OUT20/12783

**Minto Resource Recovery Facility (SSD-5339)
EIS**

The following recommendation is provided by NRAR.

PROJECT NO. P1203464	PLANSET NO. PS02	RELEASE NO. R12	DRAWING NO. PS02-E700	REVISION A
-------------------------	---------------------	--------------------	--------------------------	---------------

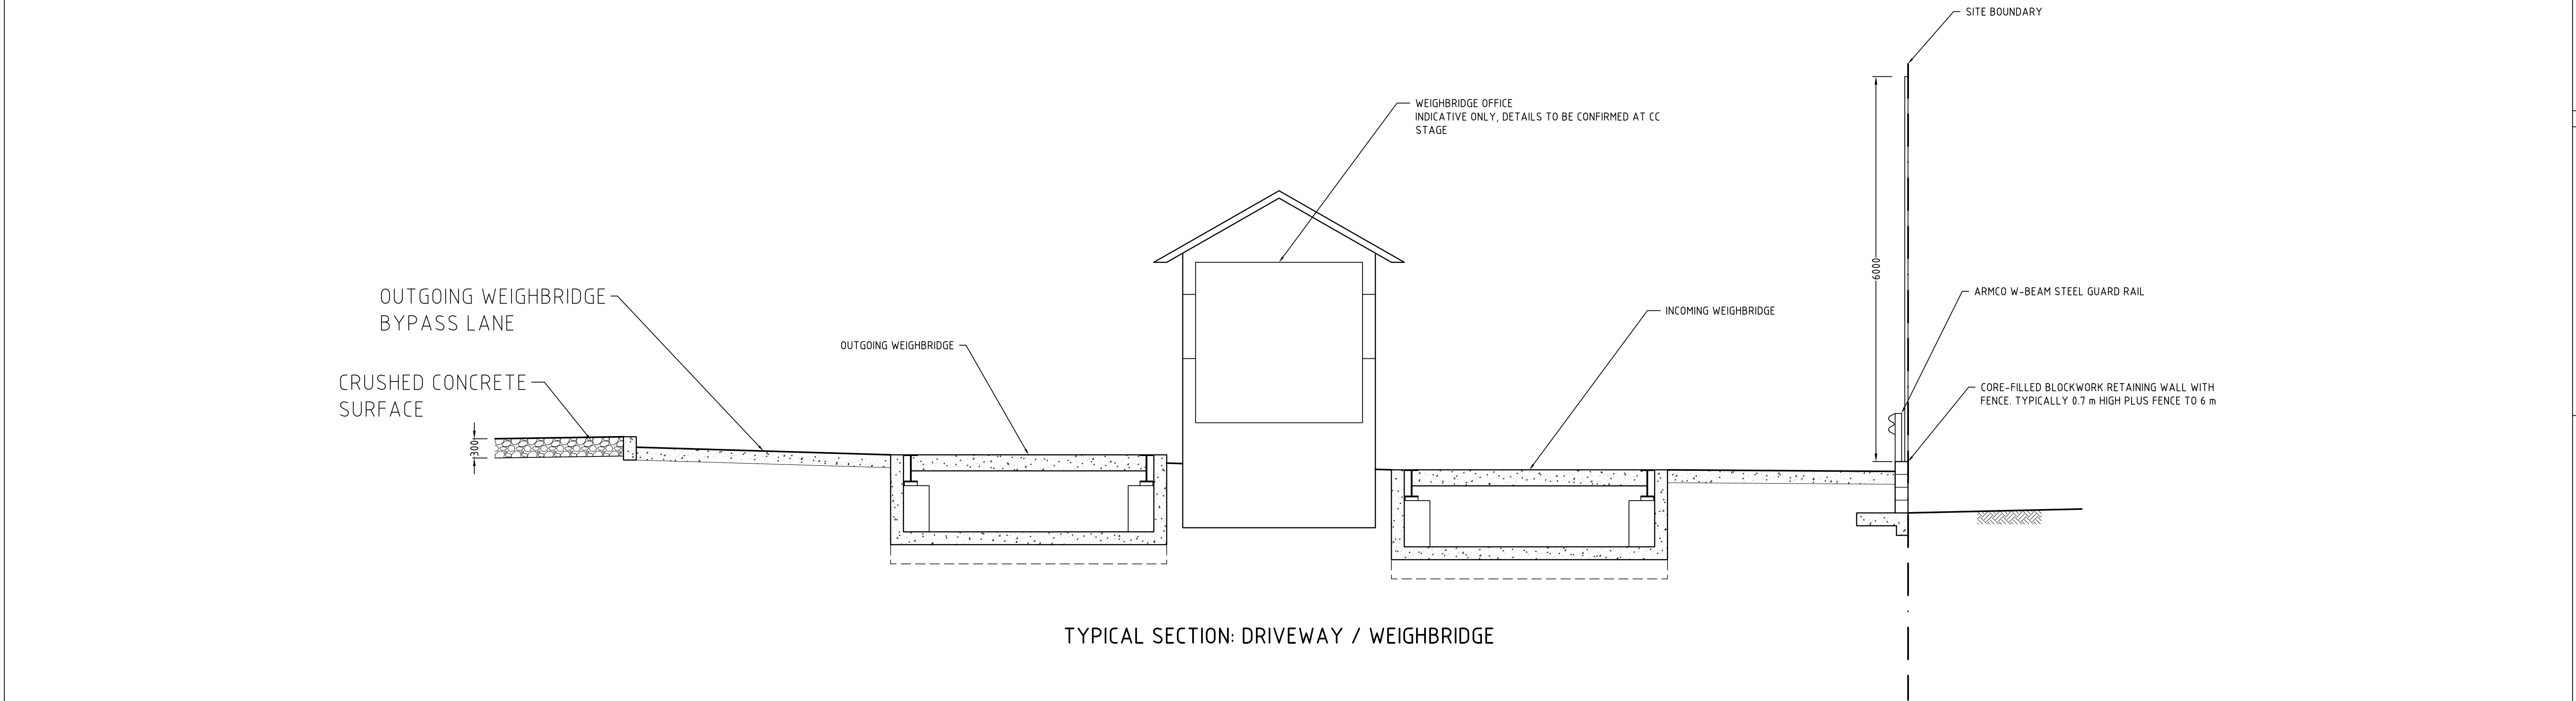
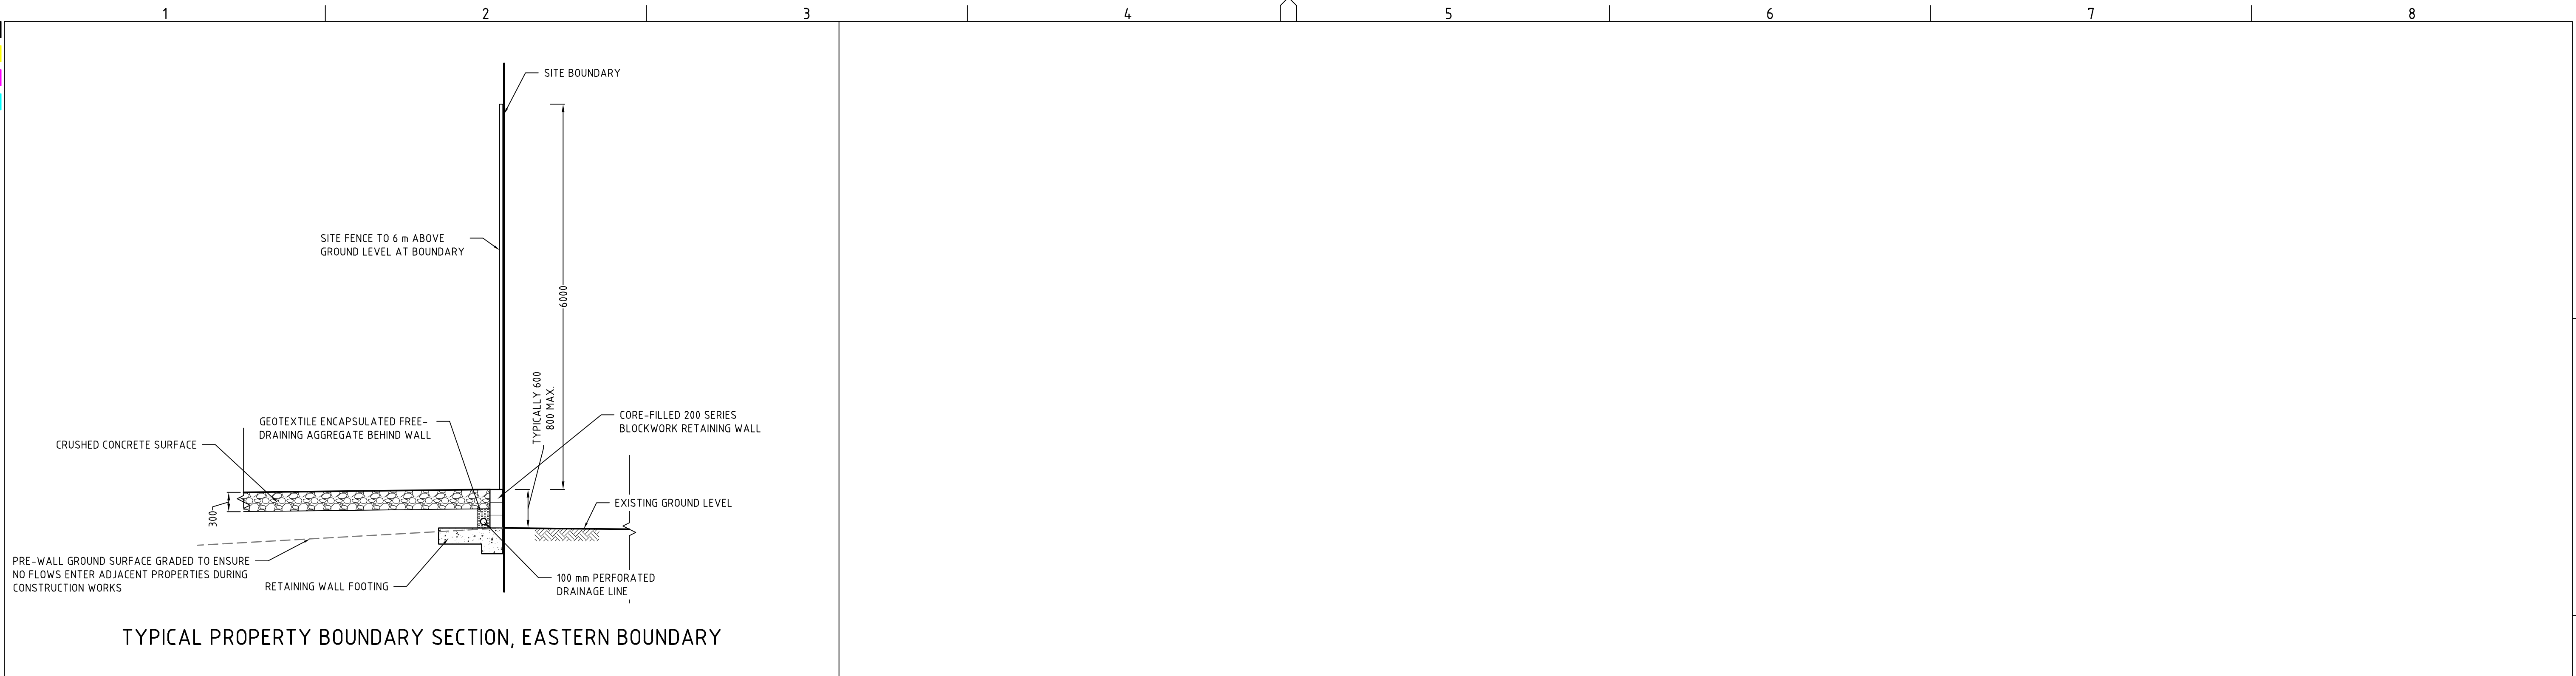
- The EIS states dust suppression and sand washing demands will be satisfied through reuse of stormwater runoff sourced from the approximately 200 kL sedimentation basins on the site. The sites sediment basins should only harvest water from the sites capture area, flow from outside the site should be redirected around the site.
